| <b>Application No</b>             | 2026/0613                                                                                                                   |
| <b>Proposal</b>                   | Amalgamation of 2x existing flats and change of use to create 12-bedroom HMO (Use Class Sui Generis) with associated works. |
| <b>Address</b>                    | Flat 1, 42 Doncaster Road, Barnsley, S70 1TL                                                                                |
| <b>Consultee</b>                  | Highways DC                                                                                                                 |

. - 417.01.1 - Proposed Basement / Lower Ground Floor and Ground Floor Plans Subject to Planning / Building Control Approval

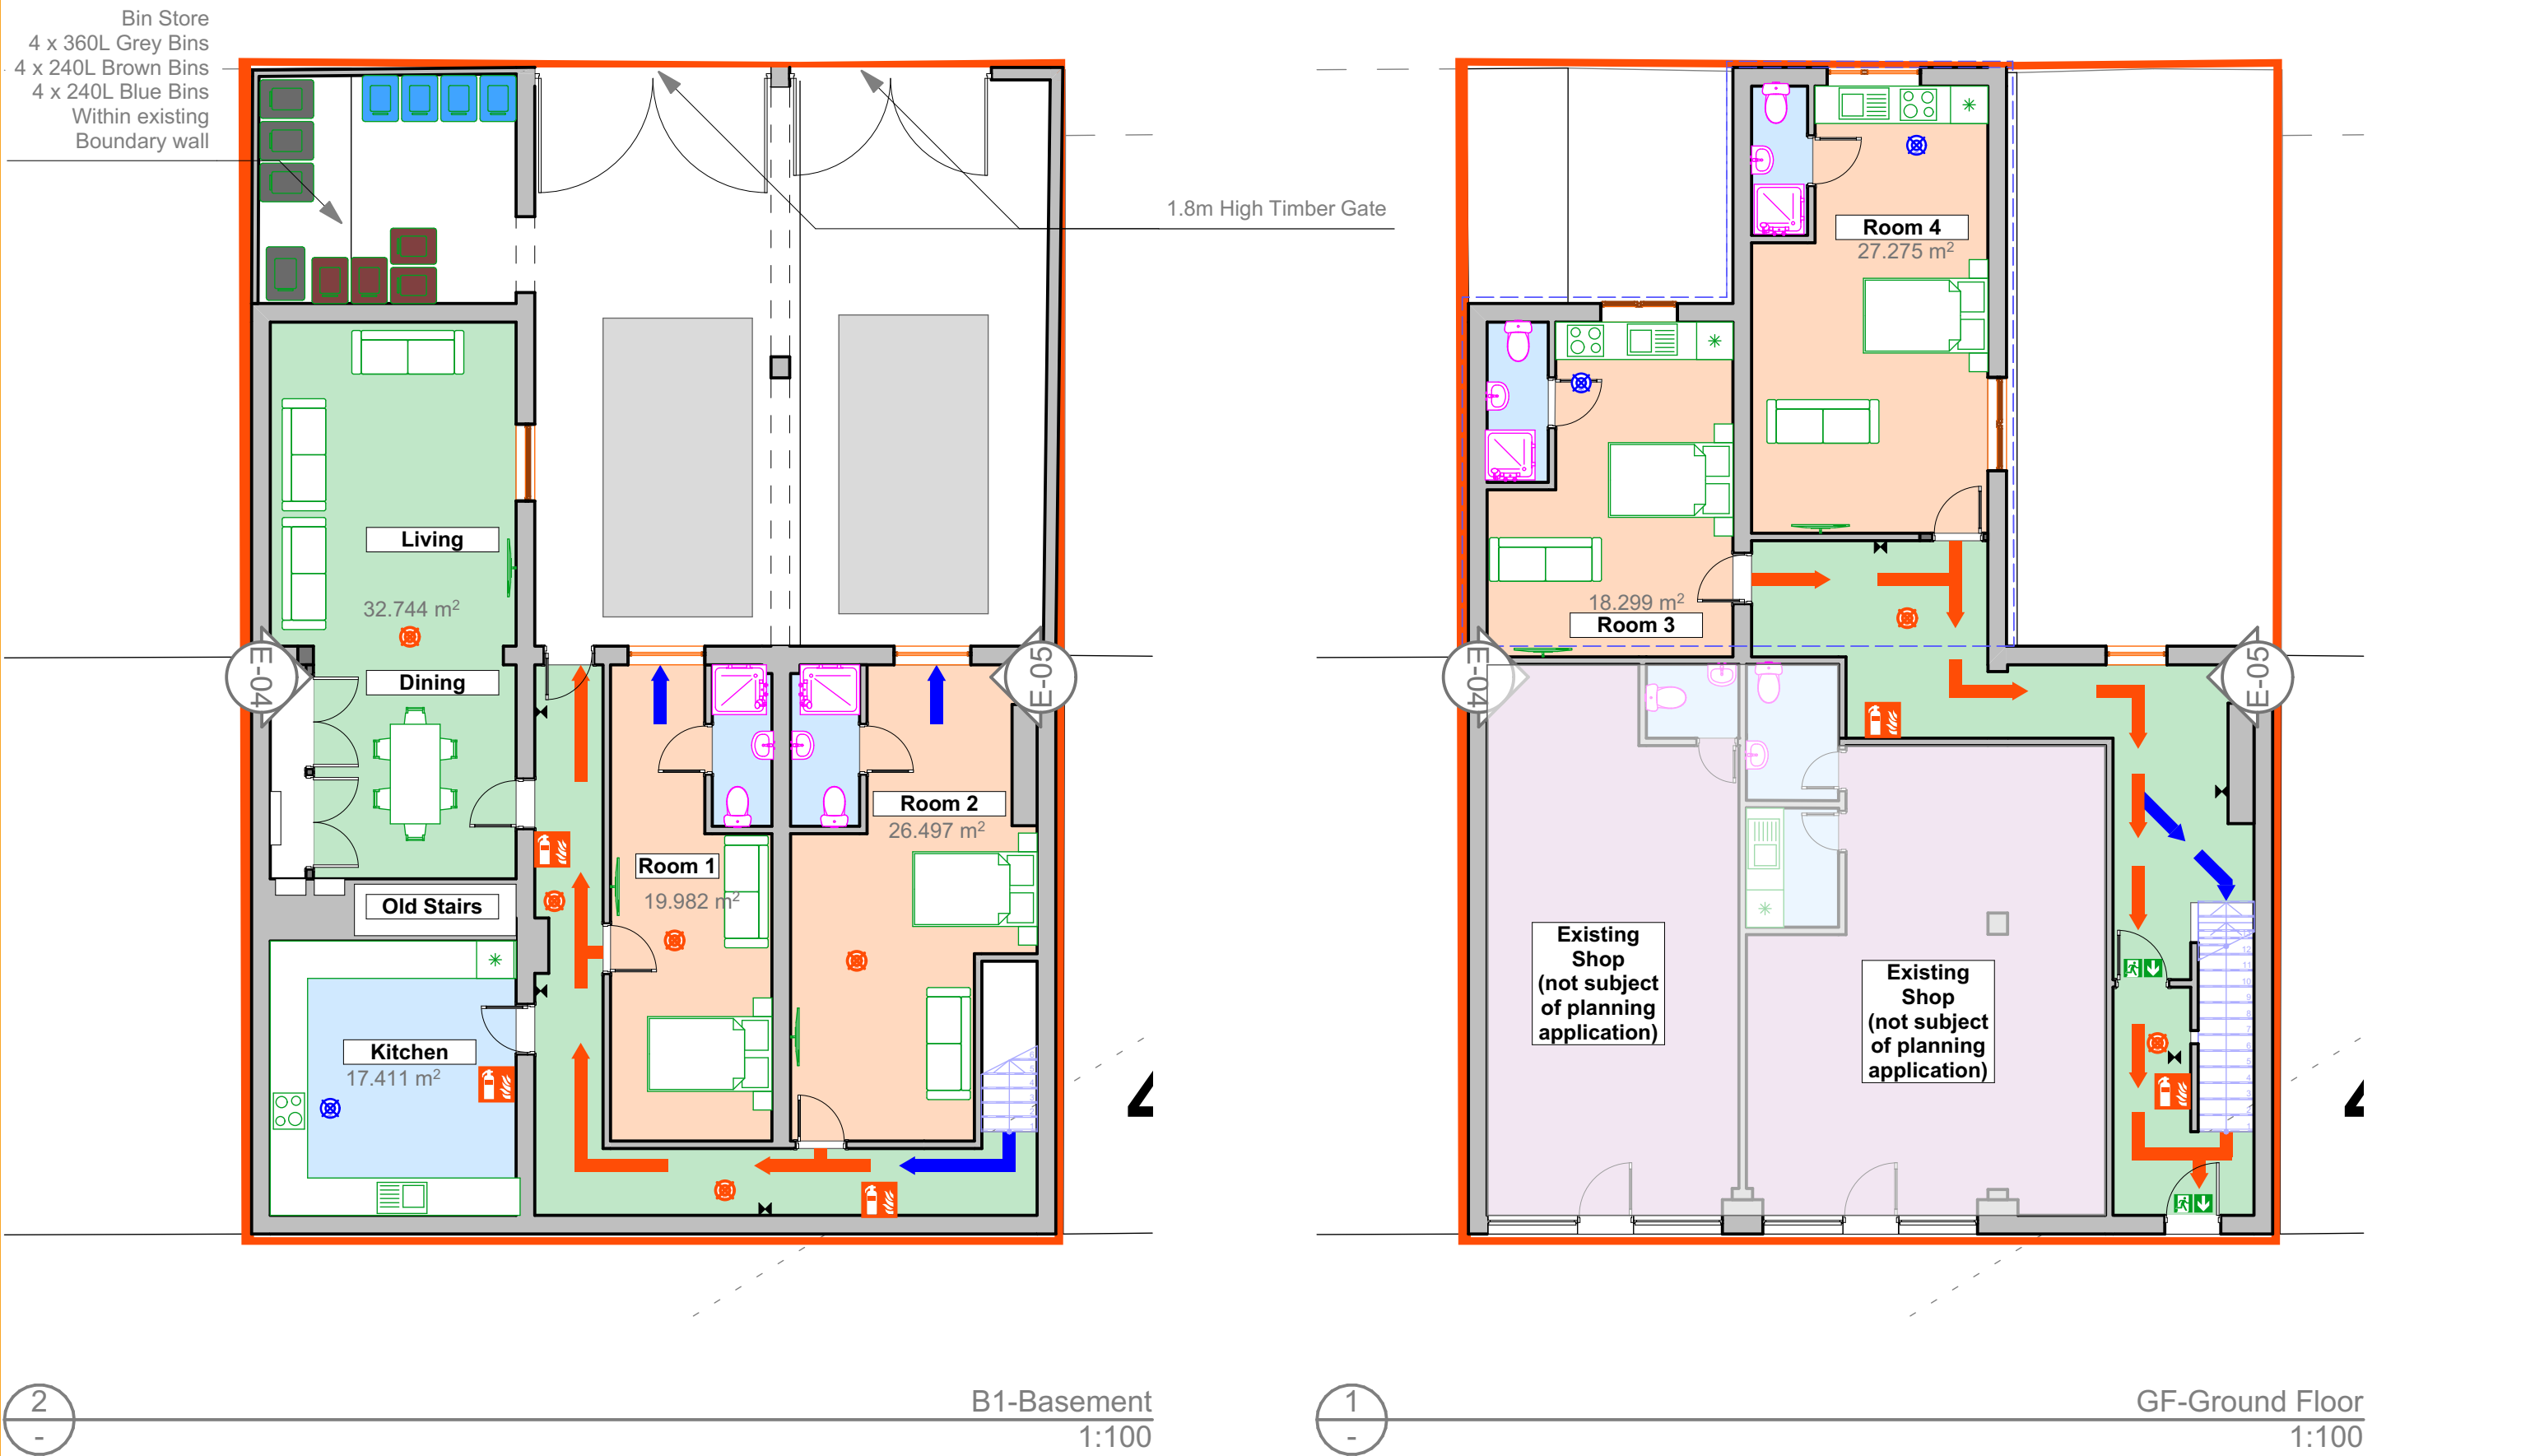
The Council's Parking SPD states that houses of multiple occupation should be supplied with one off-street parking space per three rooms. As such, the residential element of the property should presently have two spaces, and this requirement would increase to four with the proposed alterations. Whilst the applicant is providing two spaces to the rear of the property there would still be a shortfall.
